1. SSD10421 – Proposed Weigall Sports Complex – Response to Traffic Engineering Submissions

We have prepared this letter to address comments relating to parking and traffic engineering received from Woollahra Municipal Council, City of Sydney Council and the Department of Planning, Industry and Environment in relation to the subject projects.

drawing title
Swept Path Assessment - Typical B99 Vehicle

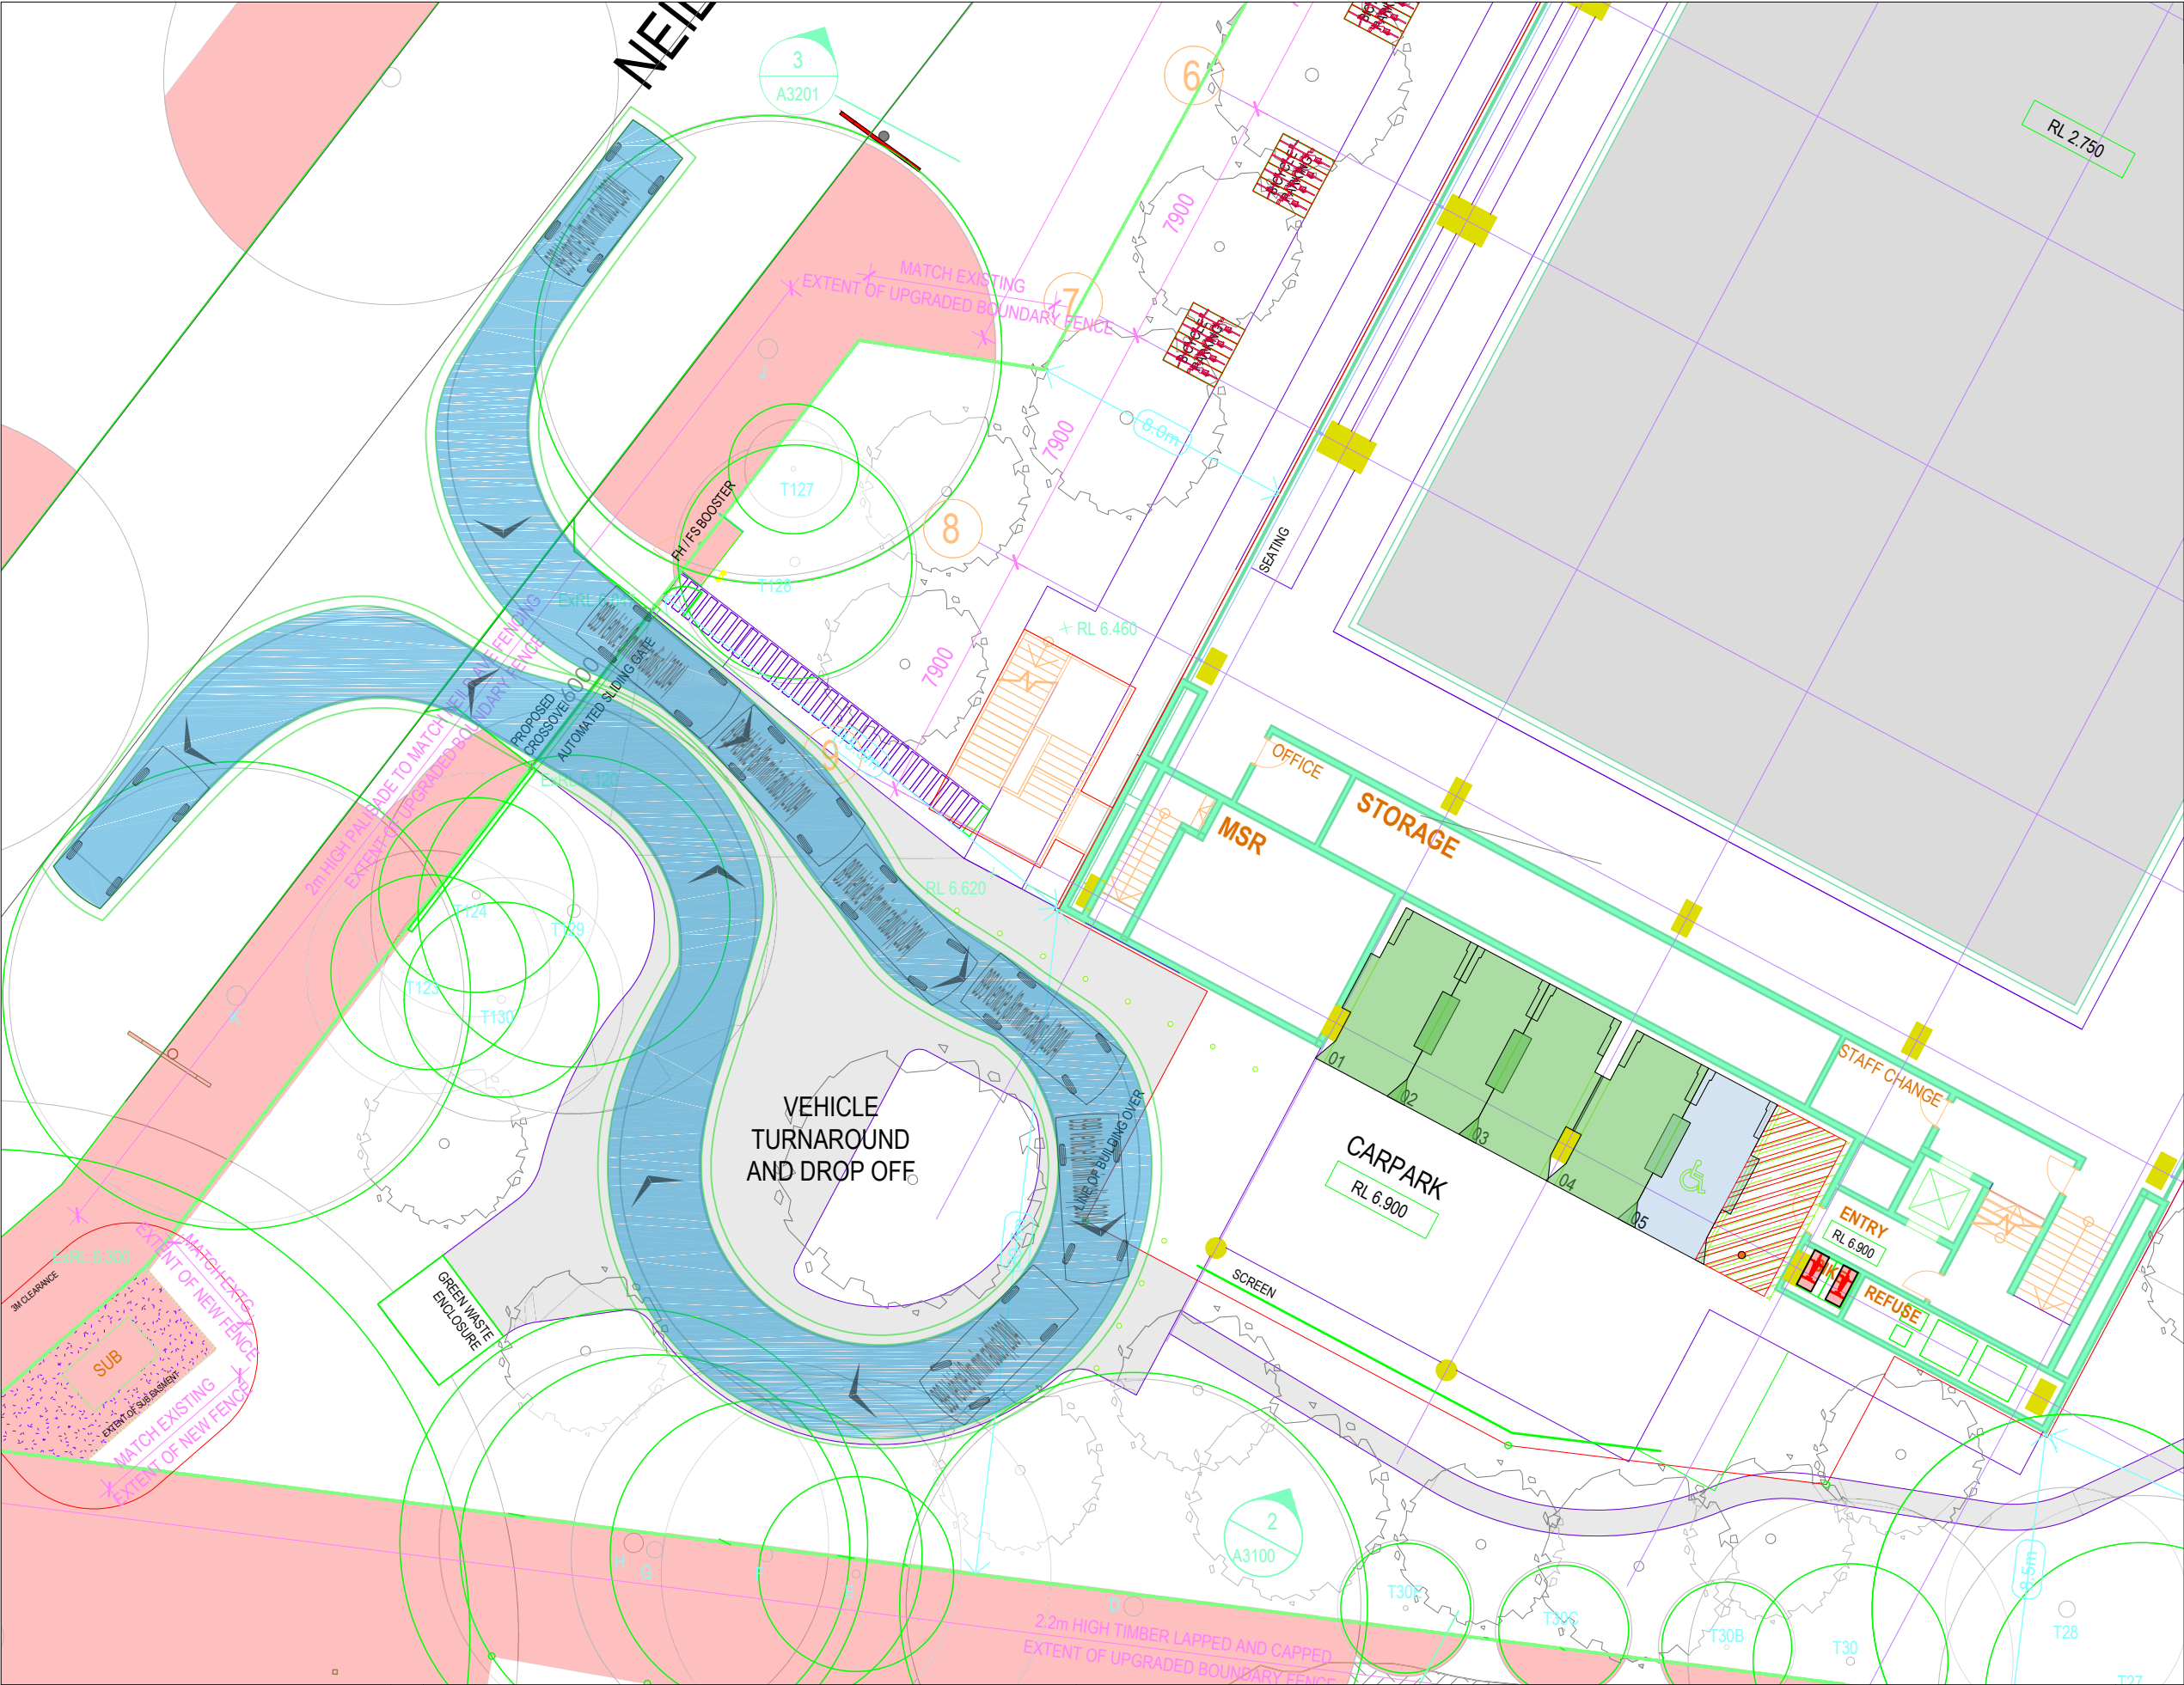
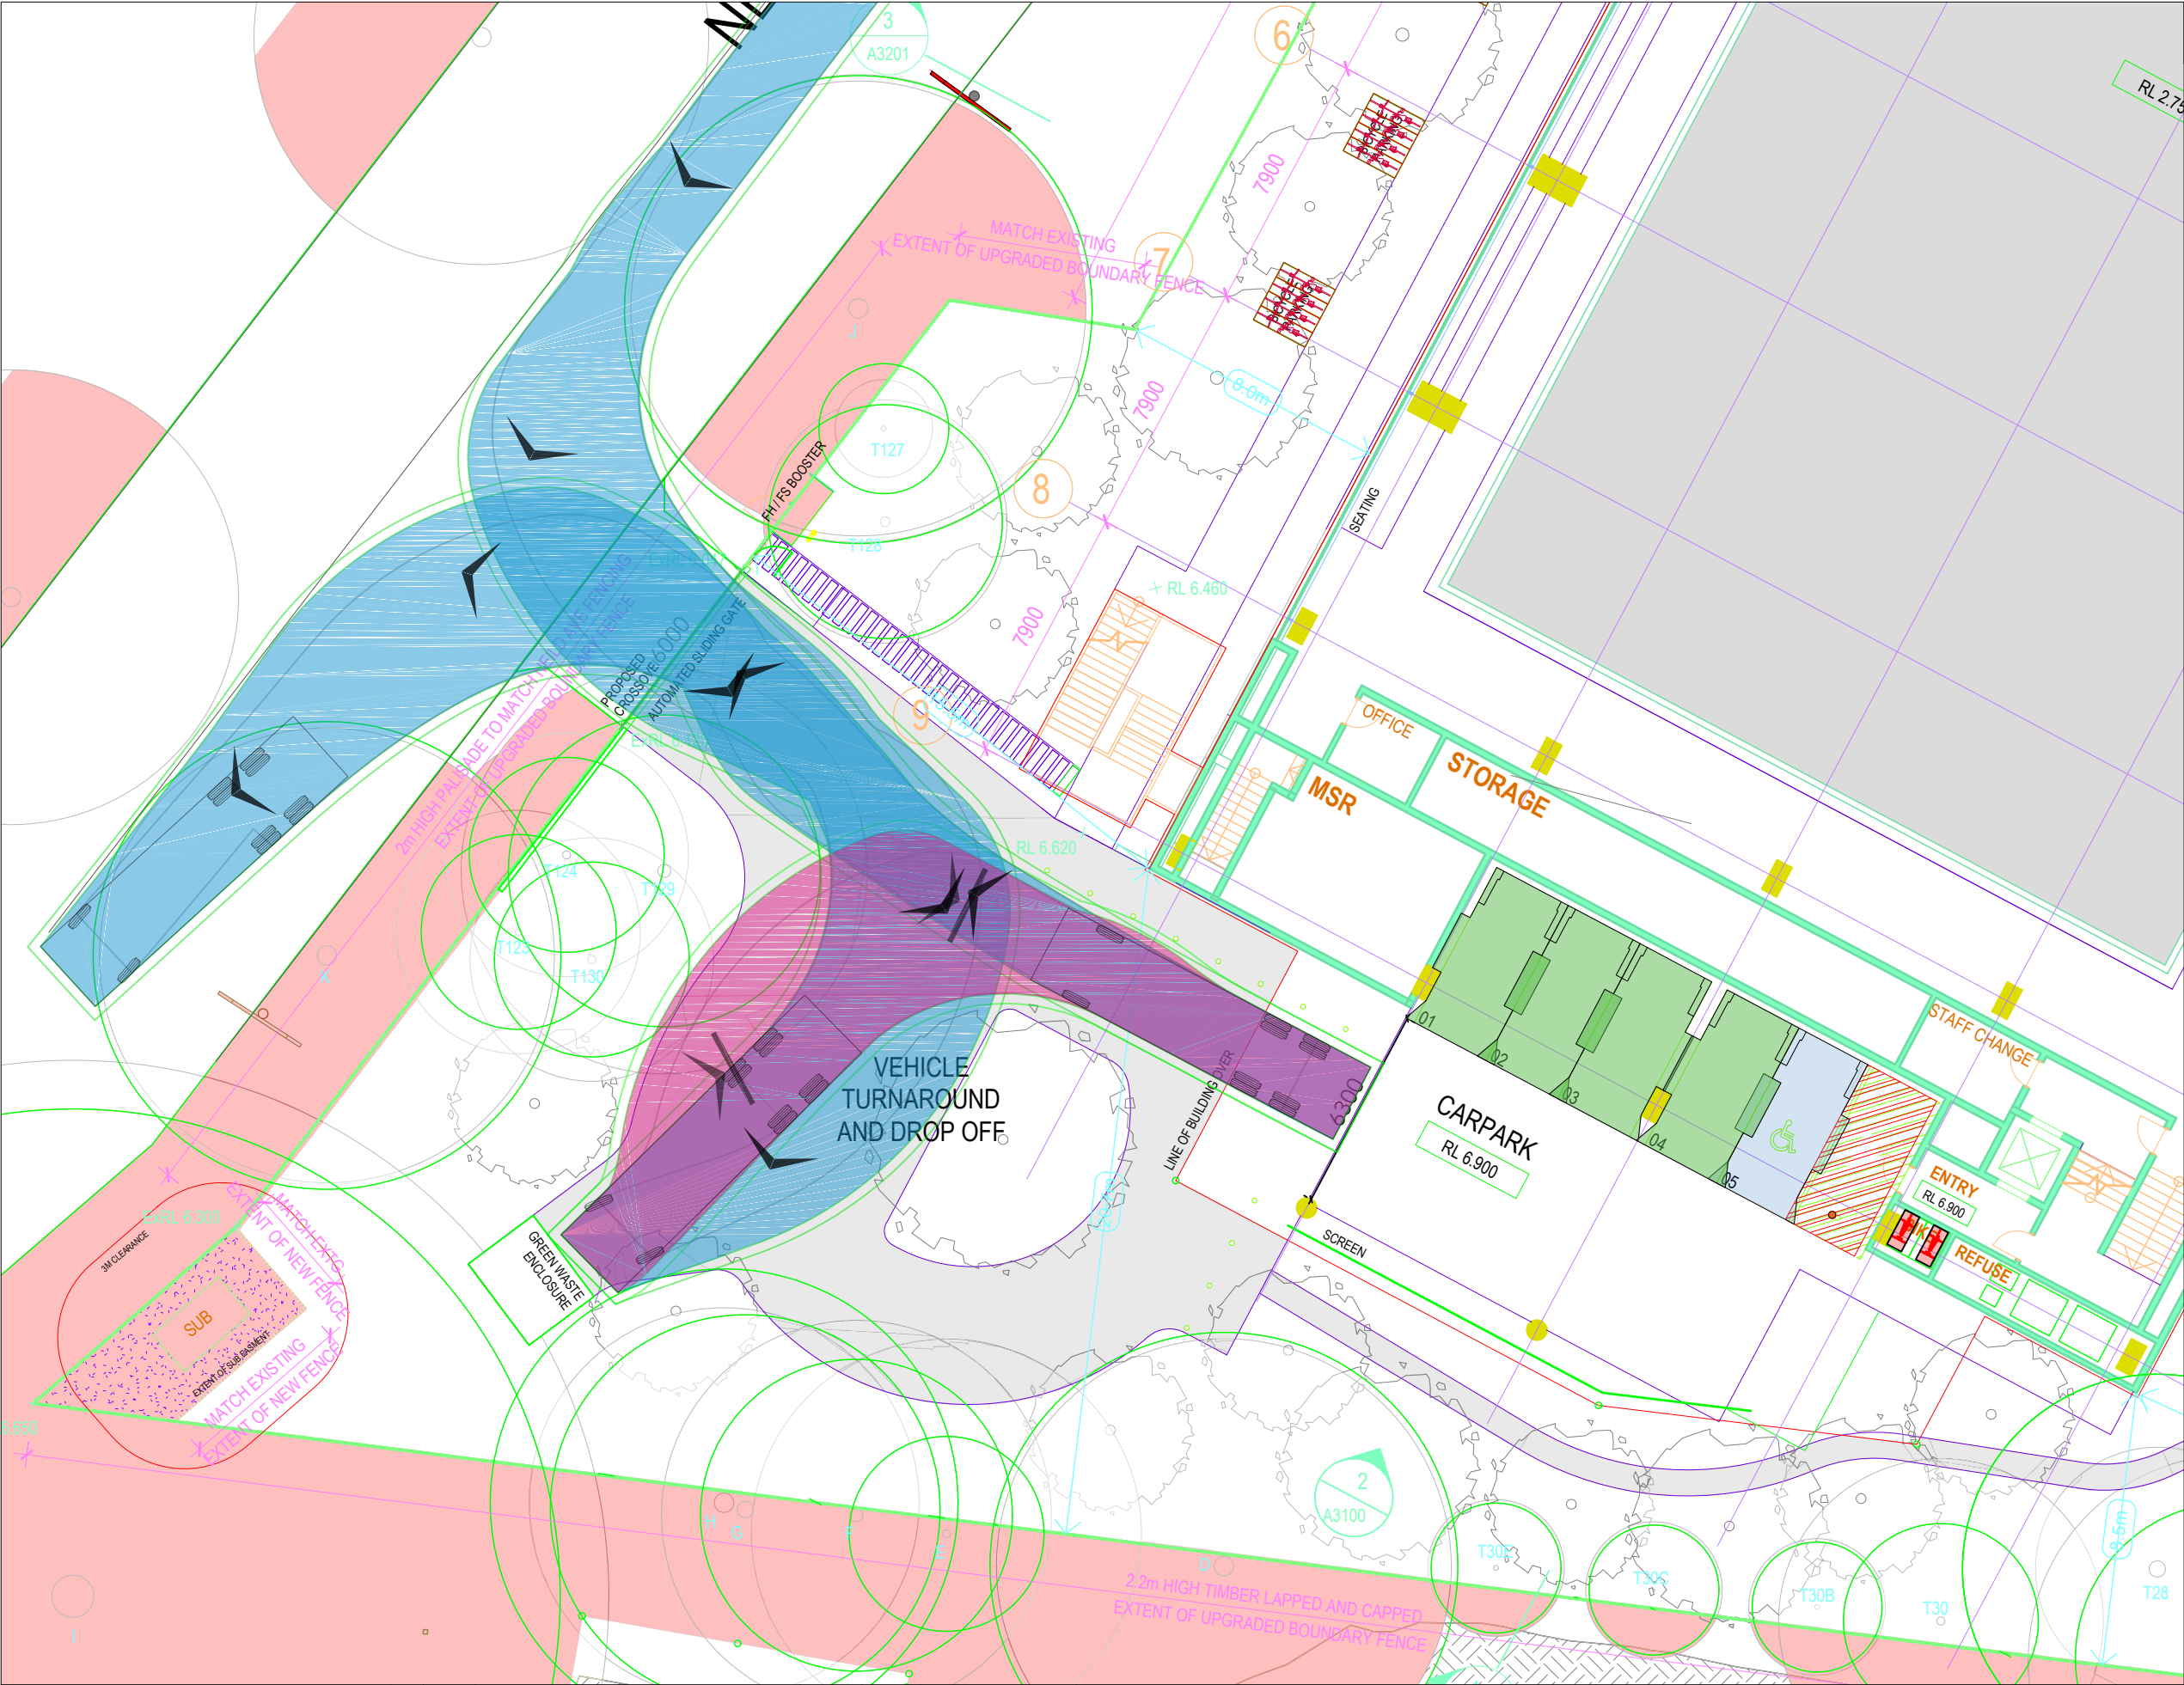
- 2) Access and egress route of construction vehicles: Restricted manoeuvres are identified in the swept path analysis on site and at roundabout of Lawson and Vialoux Avenue. It should be noted that Vialoux entrance is relatively narrow with vehicles constantly parking on the side;*

We note the comments and will revise the CTMP accordingly. This is best done when a contractor has been engaged and following the completion of the consent conditions so that work hours, truck routes and other measures nominated in the condition can be applied for and incorporated.

Figure 45 | Building 1 proposed pick-up/drop-off vehicle queuing arrangements (Source: Applicant's EIS 2020)

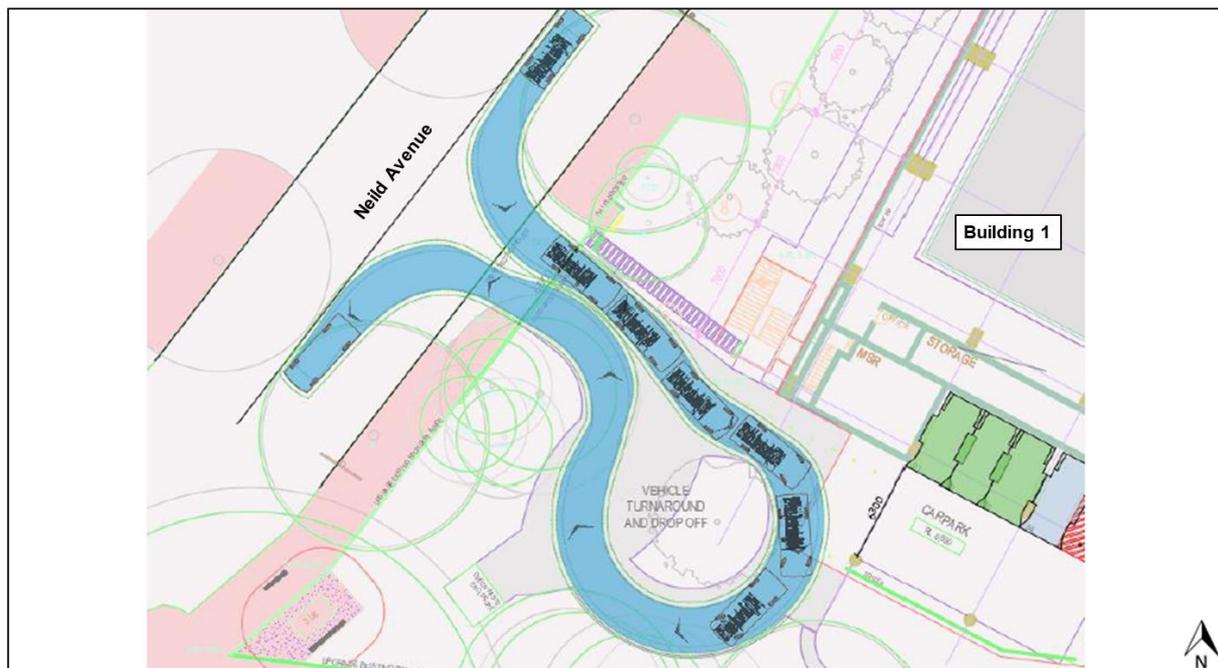
While Traffic Section in principle agrees with the assumed mode splits, average service time and duration of pick-up/drop off period, a more quantifiable queuing analysis should be submitted to demonstrate the proposed on-site pick-up/drop-off circulation area can accommodate 98th percentile queue at peak traffic levels. It should be noted that vehicles must not wait on the footpath or roadway.

In addition to the car park, the proposal includes a drop-off / pick-up area adjacent to the proposed building, having access from Neild Avenue. The drop-off / pick-up area will accommodate six vehicles at the same time. We have undertaken a Poisson Distribution analysis of the area using the peak Wednesday evening demand figures (adopting Council's calculated figures) and the typical average dwell time recorded at schools as a suitable benchmark.

Inputs			Outputs		
Total Arriving	190	Cars	Probability of queue	6.45%	
Time Period	30.0	Mins	Average length of queue	0.14	Cars
Arrival Time	9.5	Seconds/Car	95th percentile queue	0	Cars
Service Time	30.0	Seconds/Car	Average time in system	31.29	Seconds/Car
No. of Services (N)	6	Spaces	Average time in queue	1.29

The results indicate that adopting a 30-minute pick-up period and applying the 190 vehicles within this period (this ignores cars arriving outside the 30 minute period and therefore presents a robust assessment) there would be no queue (95th percentile) and a 6.45% of any queue.

Extending the pick-up period to a more realistic 45 minutes reduces this probability to 0.81% chance of a queue.
